DECISION DELEGATED TO DEVELOPMENT MANAGER

Application No: H15-0185-20 **Applicant:** Mrs J Kane-Stacey

Proposal: Details of external materials, external boxes etc, landscaping and boundary treatment, contamination and archaeology (Conditions 3, 4, 5, 6, 7, 8, 9 and 10 of H15-0582-19)

Location: 62 Water Gate Quadring Spalding

DRAWING:
EXTERNAL WORKS 1

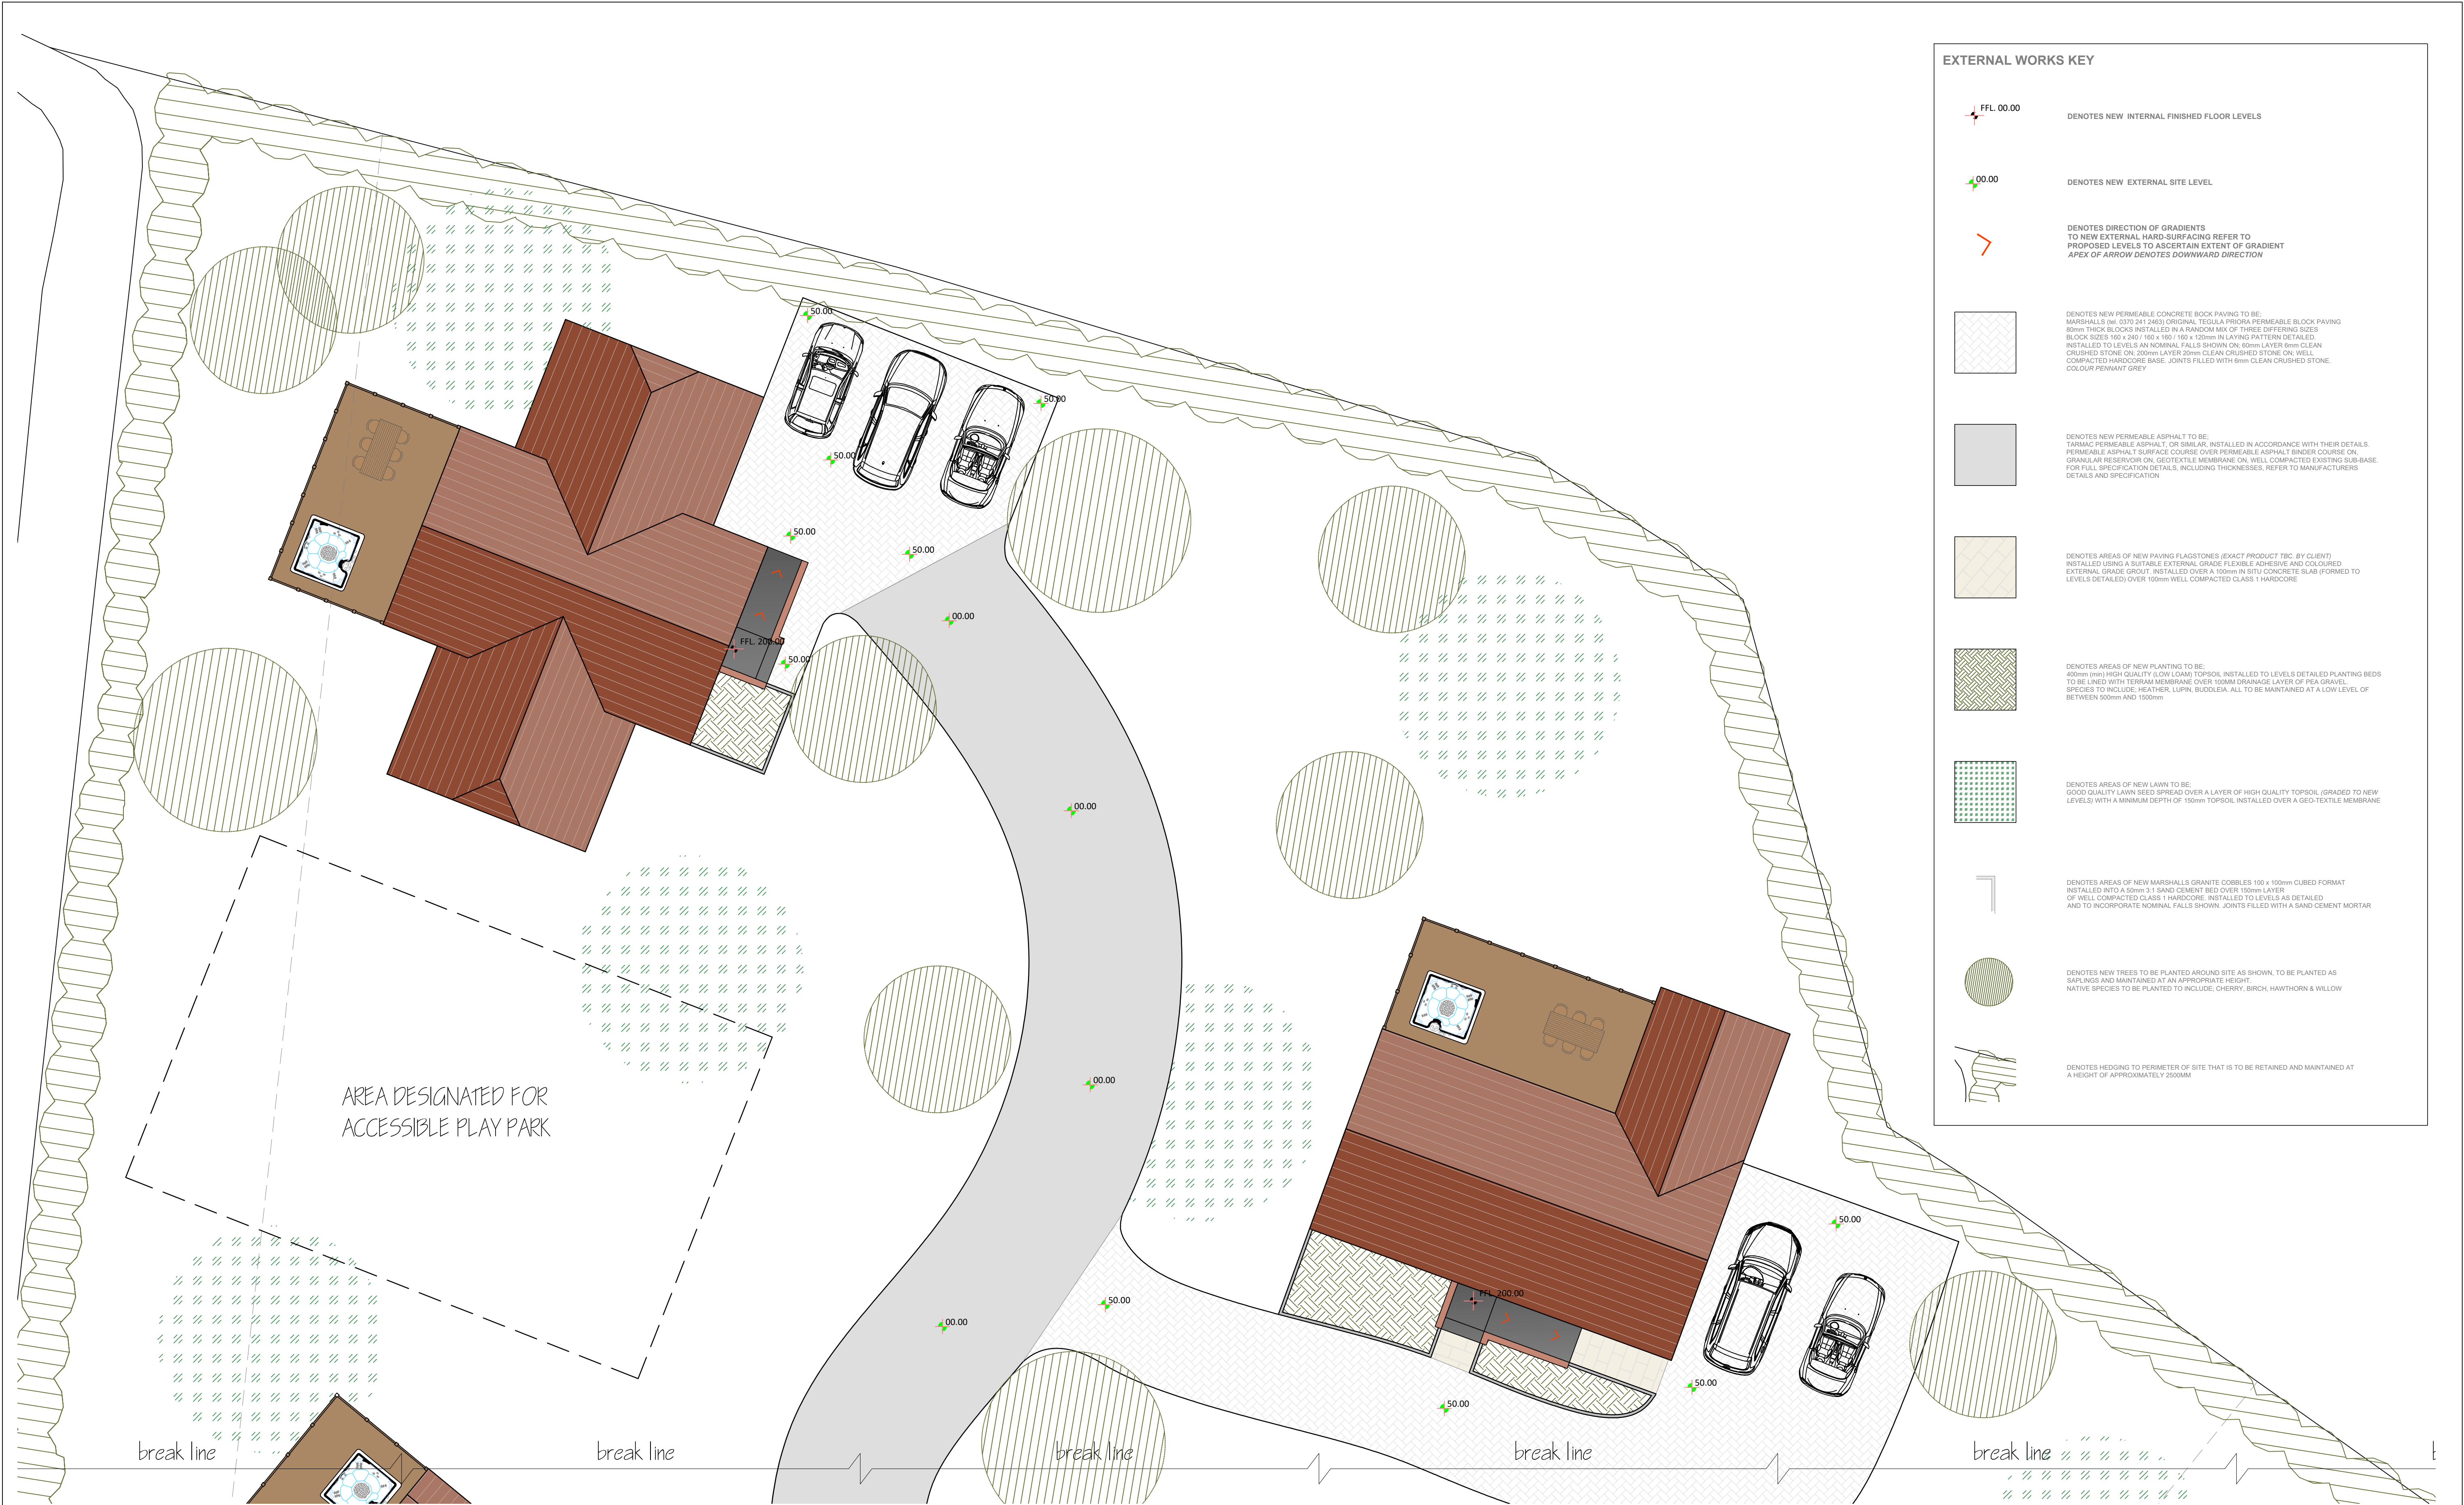
The proposed landscaping details shown on plans 0152/19/CC04 and 0152/19/CC05 are considered to compliment the proposed buildings and do not hinder occupant amenity. Condition 5 can now be discharged.

Hedging around the perimeter of the site is to be retained and maintained at a height of 2.5 metres. The proposed boundary treatment is considered to be appropriate for the site. Condition 6 can now be discharged.
